APPEAL STATEMENT

Planning Inspectorate Reference:	APP/T2350/W/17/3178692
LPA Application Reference:	3/2017/0192
LPA Officer:	Stephen Kilmartin

Full planning consent for the change of use from former agricultural building to one dwelling

Countess Hey, Elmridge Lane, Chipping PR3 2NY

south elevation

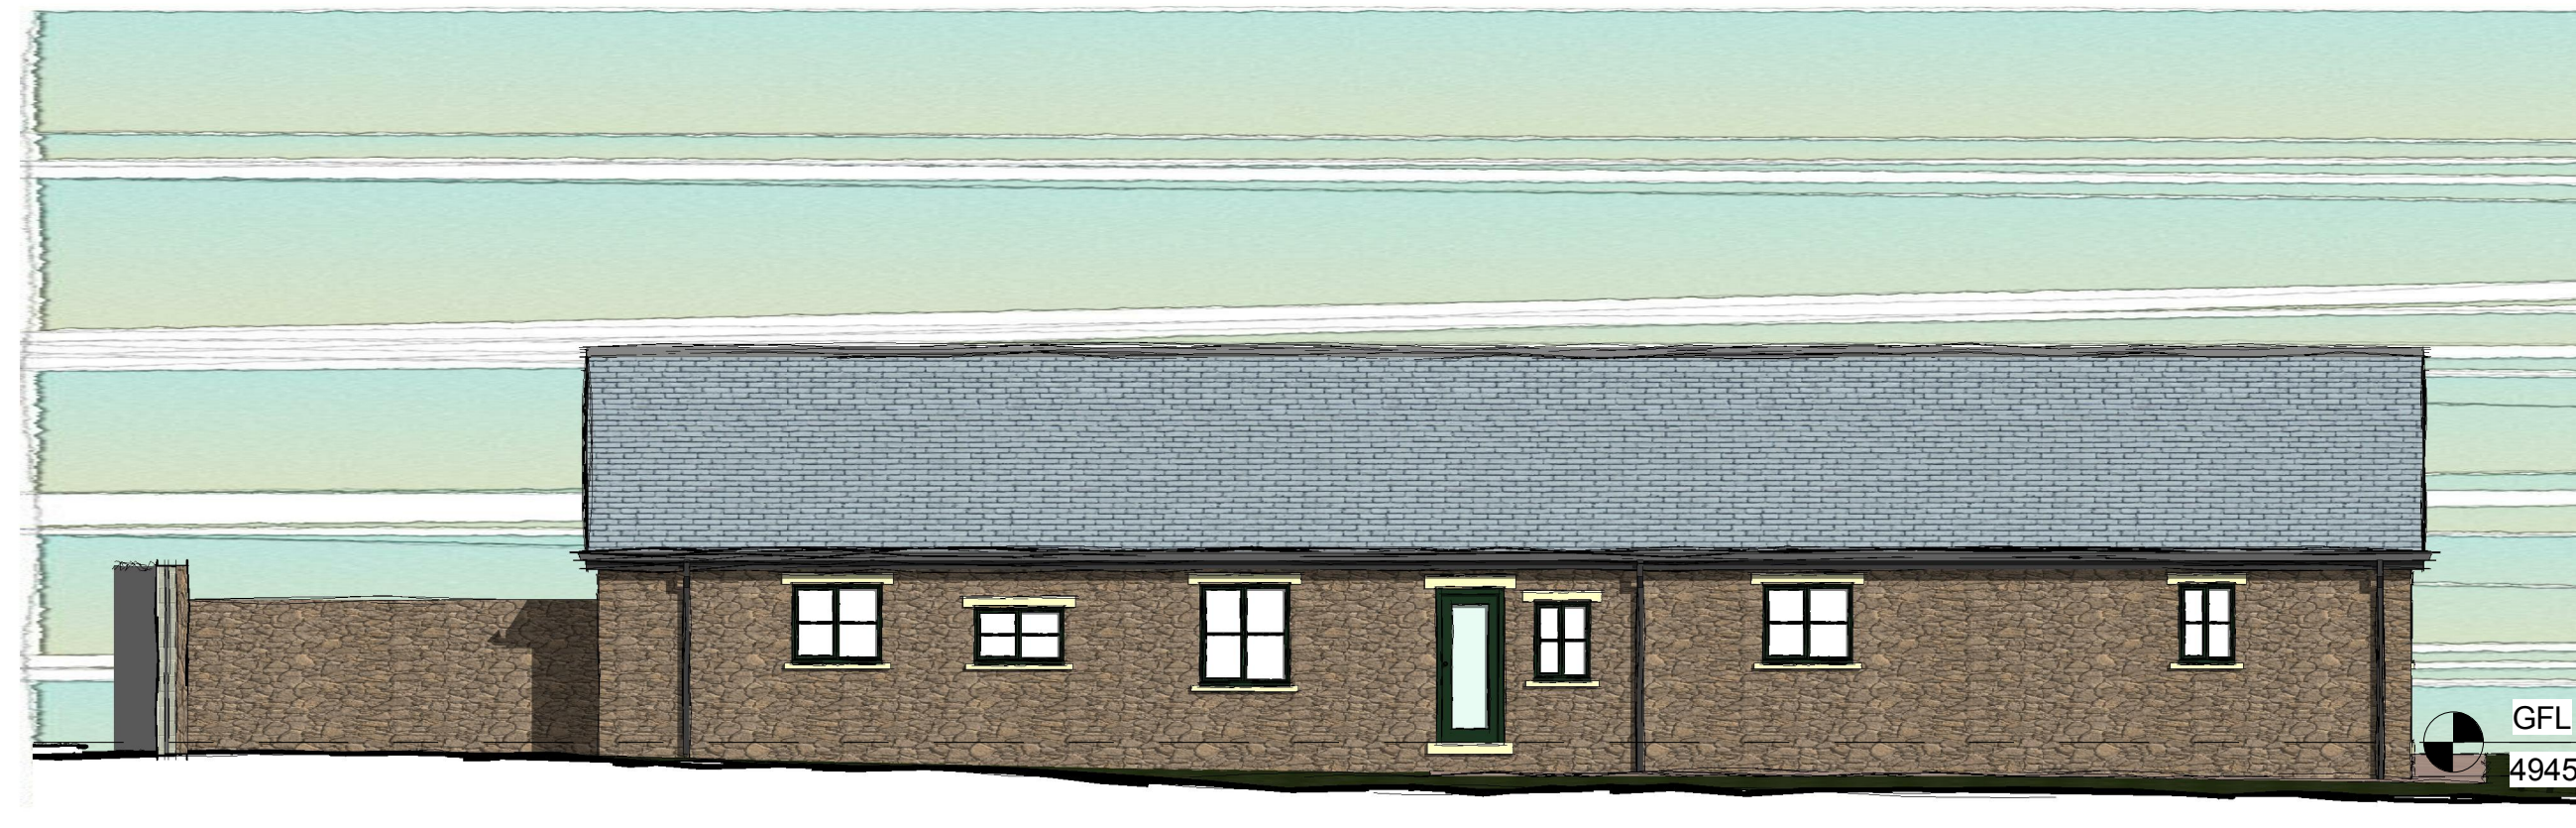
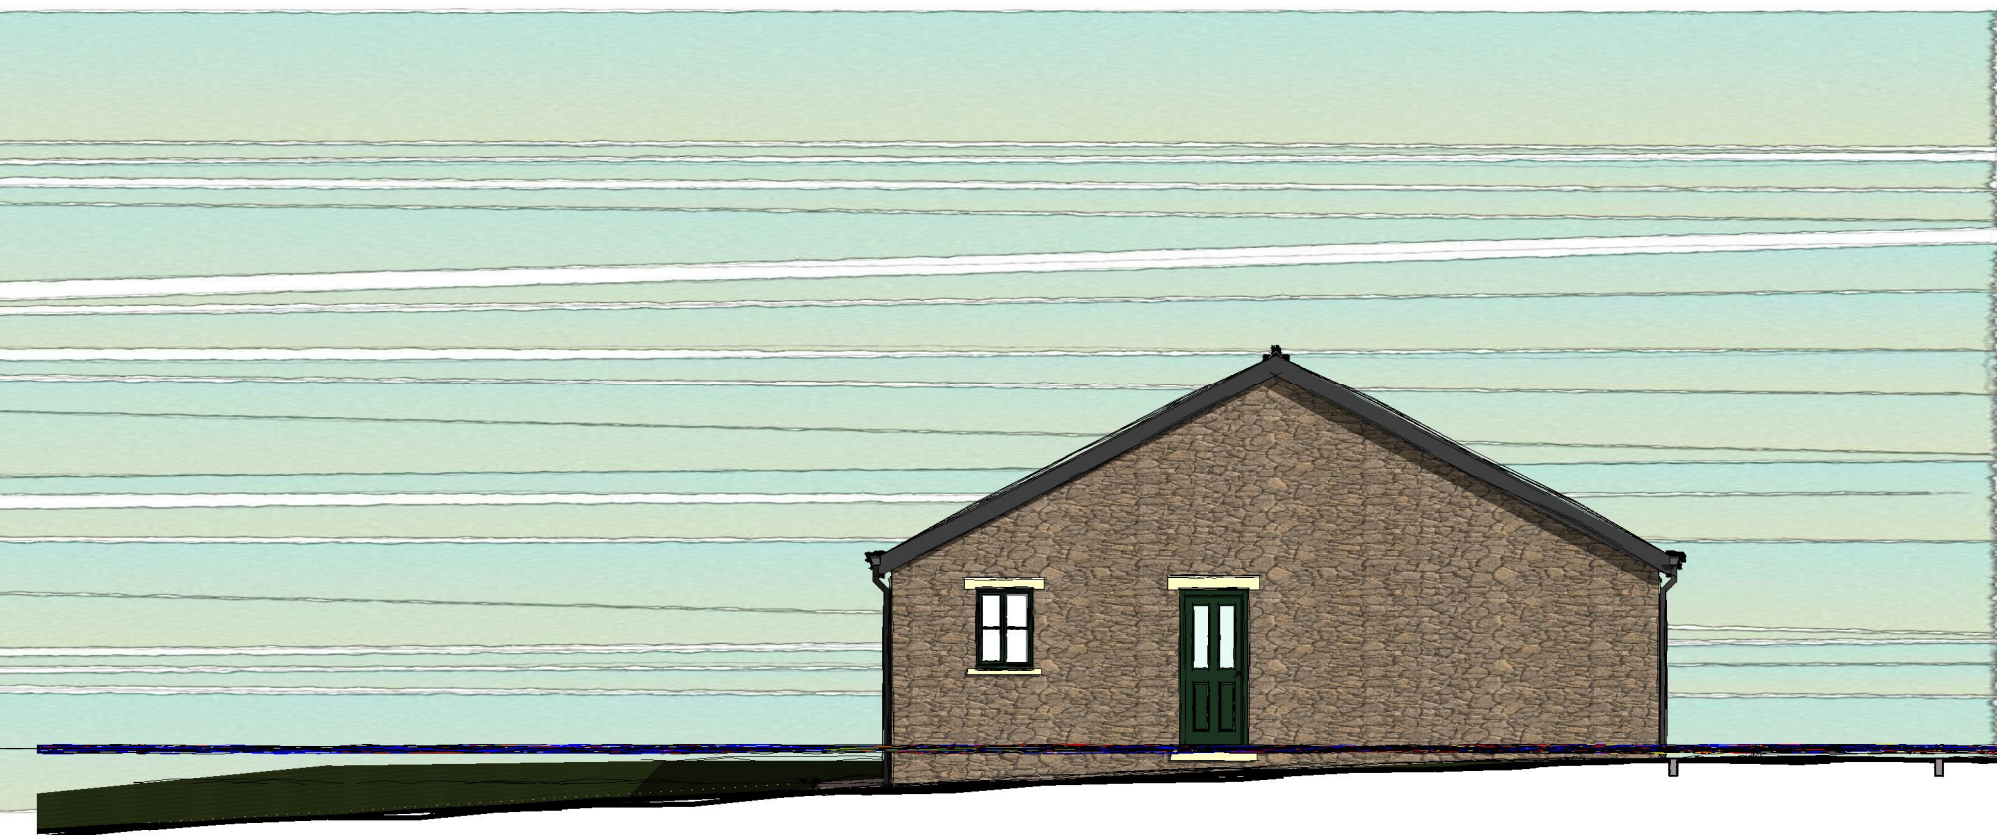
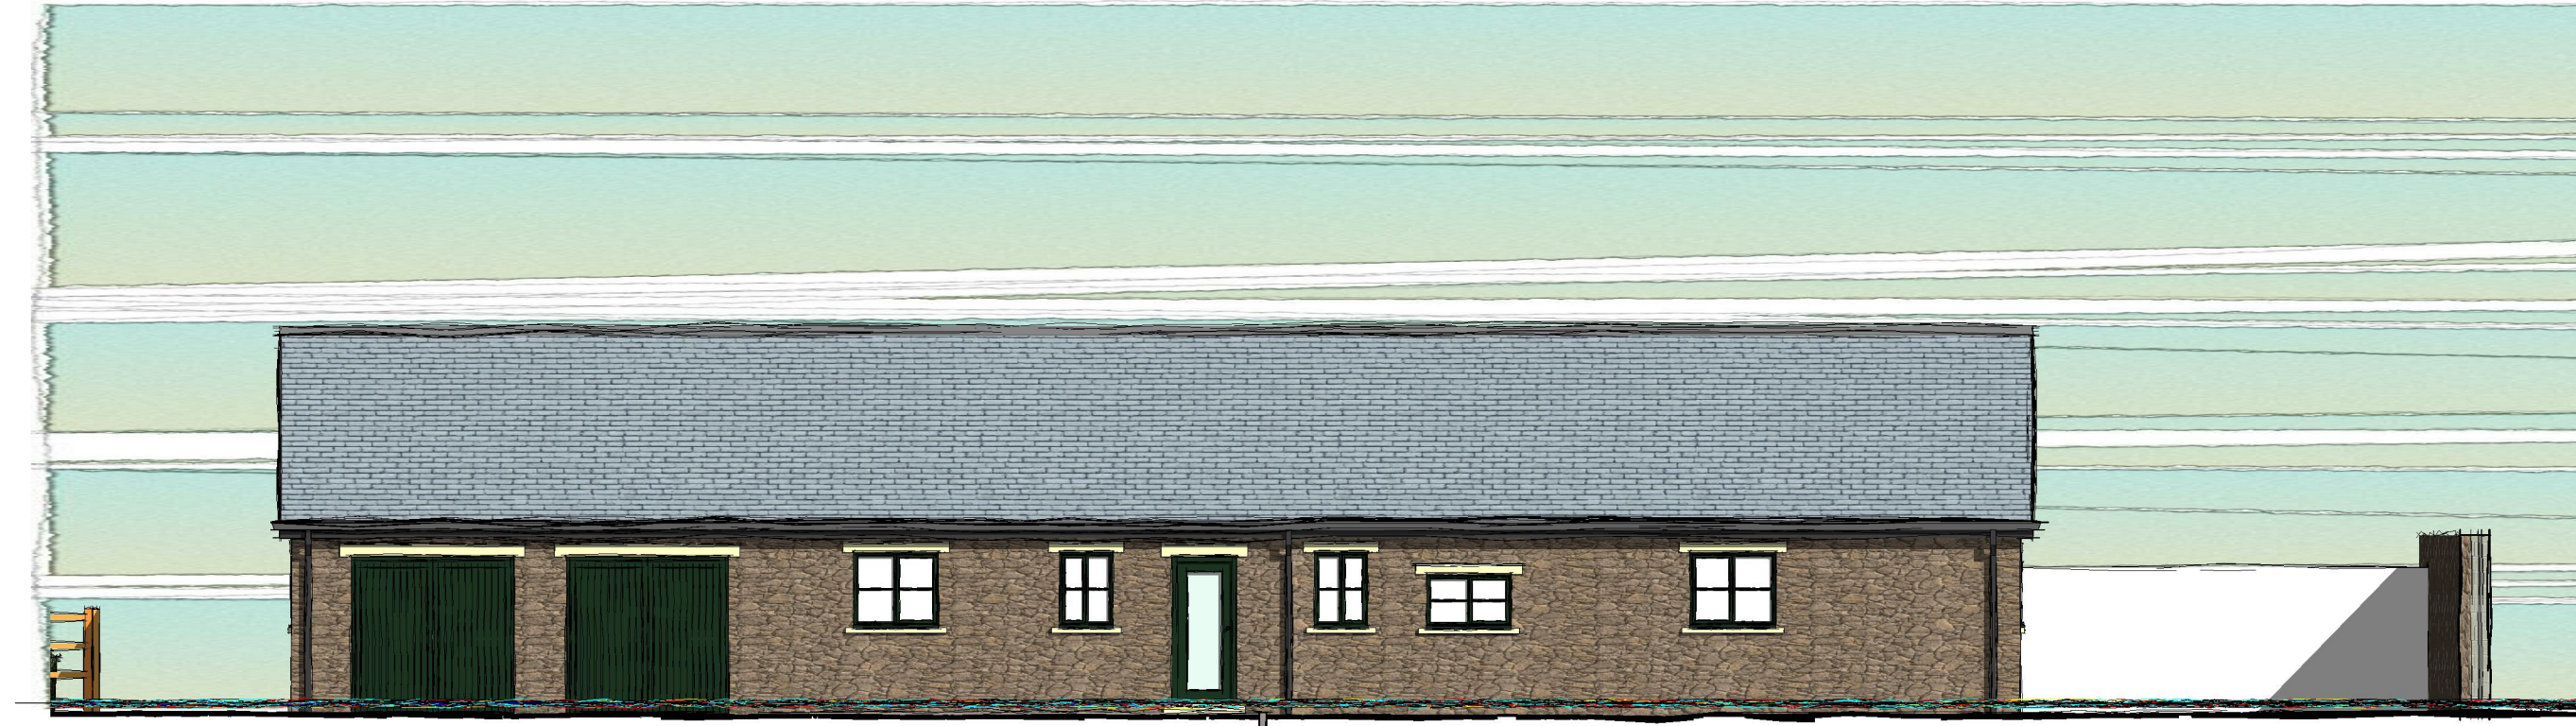
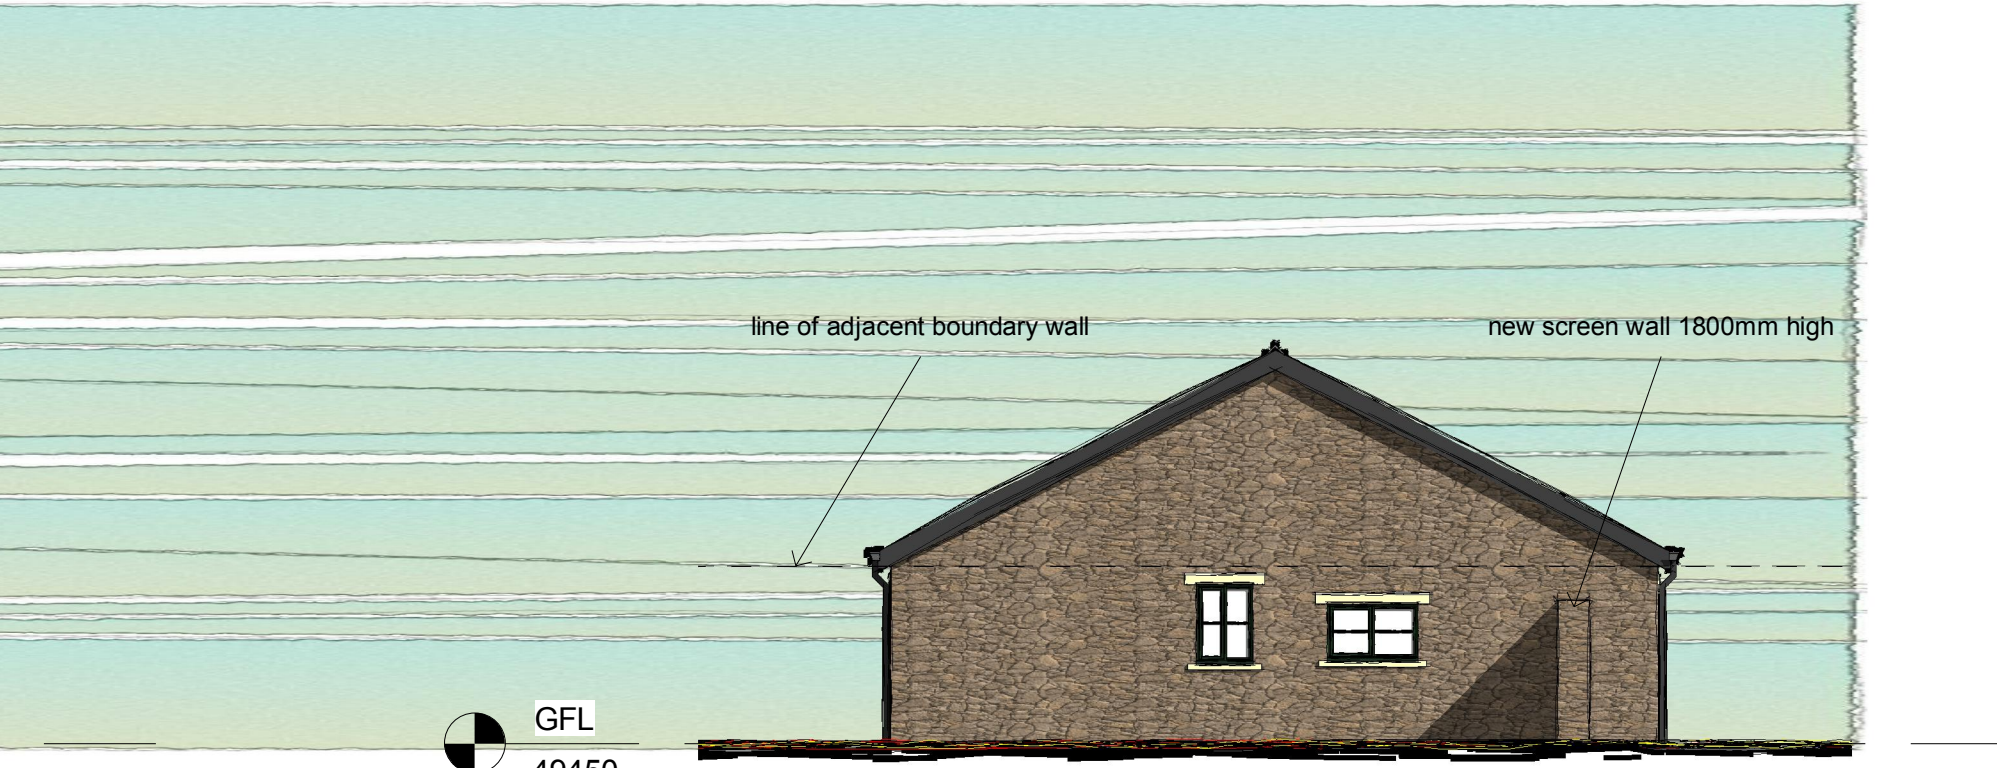
- Remove existing gable west elevation and demolish portion of building
- Re-cover existing roof with natural blue/grey slates
- Cladding of all external walls of the building in natural stone.
- North Elevation: Introduction of 5 window openings, one door opening and two garage door openings.
- South Elevation: Introduction of six windows openings and one door opening
- East Elevation: Introduction of one window opening and one door opening
- West Elevation: Introduction of two window openings.
- Creation of a residential curtilage (excluding the footprint of the dwelling) of 882.6sq.m
- Erection of boundary fencing/walling to demark proposed residential curtilage.
- Creation of vehicular access point to north of application site.

7.3 Clearly the proposed works are extensive and it is respectfully requested that the Inspector note that the aforementioned windows and doors (19 in total) fails to utilise any of the existing openings on the existing building save for those that are to be 'infilled' to accommodate smaller apertures.

7.6 It is considered that proposal would result in the introduction of a dwelling that fails to contribute or enhance its immediate setting by virtue of its overtly domestic appearance which fails to respond positively to the rural characteristics of the area. The authority considers that the proposal would appear incongruous upon the landscape insofar that it would appear more akin to a large domestic bungalow than that of a typical rural conversion. This is exacerbated through the introduction of a large number of domestically proportioned window/door openings and the double integral garage door arrangement.
